# MONA OFFSHORE WIND PROJECT

## Response to Davis Meade Property Consultants on behalf of Jennings Building & Civil Engineering Limited CAH2

Application Reference: EN010137

Document Reference: S\_D6\_33

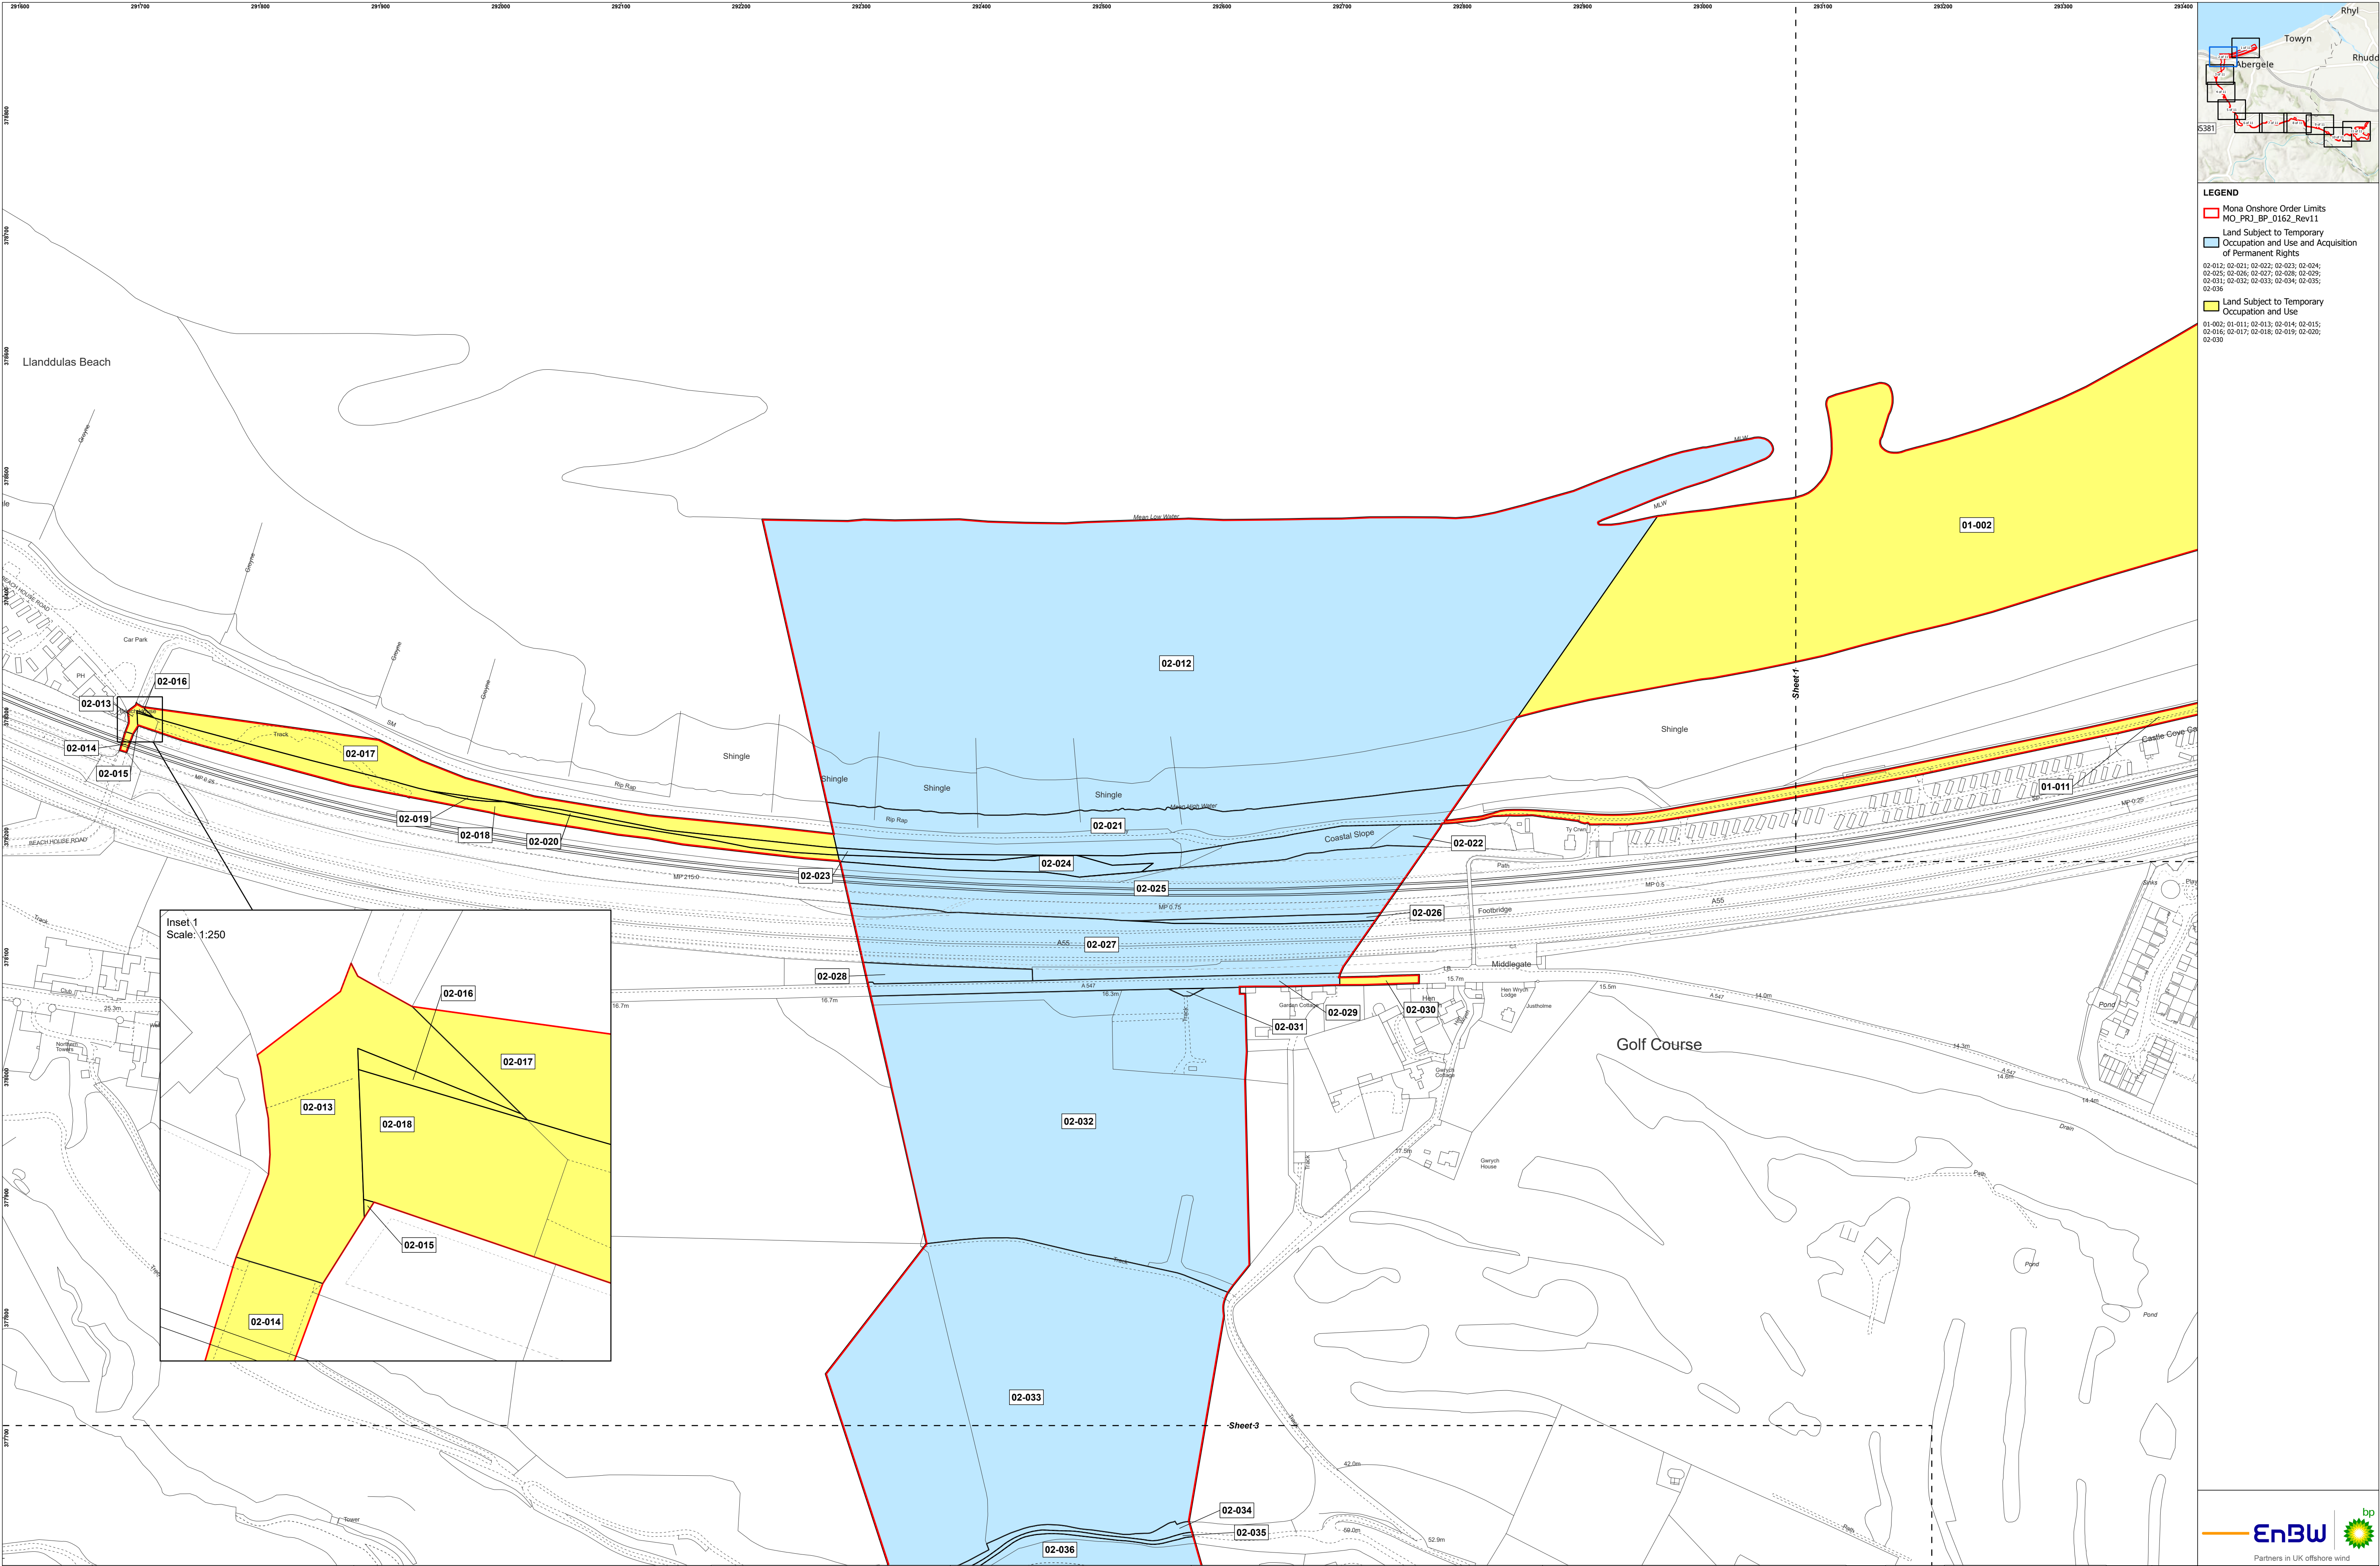
<p>REP5-111.4</p>	<p>Unfortunately ,the specific location of the proposed easement strip isn't known but it is interpreted that the same would be sited within the area coloured blue forming part of Plots no 02-021,02-023 &amp; 02-024 on the Land Plan:- B5_Mona_Land Plan (Onshore) - being estimated to be where marked between the two pink lines on the attached draft Heads of Terms plan</p> <p><i>[which also identifies our Client's further affected property ( applicable to the draft heads of terms for proposed voluntary agreements -to which consensus has not yet been achieved) tinted in green thereon].</i></p>	<p>The location of the cables within Work No. 8 at this stage of the project is not known, but further information will be provided once detailed design has been completed.</p>

Planning Inspectorate Ref. No.	Submission comment	Applicant's response
REP5-111.5	<p>3. Given the understanding of the significant depth of the intended cables under Plots no 02-021,02-023 &amp; 02-024 on the Land Plan (and the associated impracticality of excavating via the ground surface above the same for future repairs and maintenance etc) whether it is possible to remove the rights (albeit excepting for the installation ,use and decommissioning of the subject apparatus) together with restrictive covenants, as detailed in Table 2 of the Book of Reference [EN010137-001229-D4_Mona_BoR F05 clean.pdf (and associated draft Development Consent Order regarding which I interpret Schedule 8 would apply -SI/SR Template )], that would adversely impact the future potential development of the affected party's land. That is, surely it would be deemed unreasonable to impose rights and restrictive covenants which are unnecessary and blight our client's property in consequence.</p>	<p>The depth of the landfall trenchless crossing at this location has not yet been determined. The class of acquisition of the plots the Applicant is seeking at this location (relating to plots 02-021; 02-022; 02-023; and 02-024) are cable rights under existing infrastructure and restrictive covenants. As Paragraphs 1.10.1.6 to 1.10.1.9 of the Statement of Reasons (APP-029) describes, this class of acquisition aims to '...prevent any interference with the existing use, damage to that infrastructure or environment' and once the cables are installed, the buried cables can co-exist with the existing land uses, which can resume, resulting in minimal interference to the owners and occupiers'.</p>
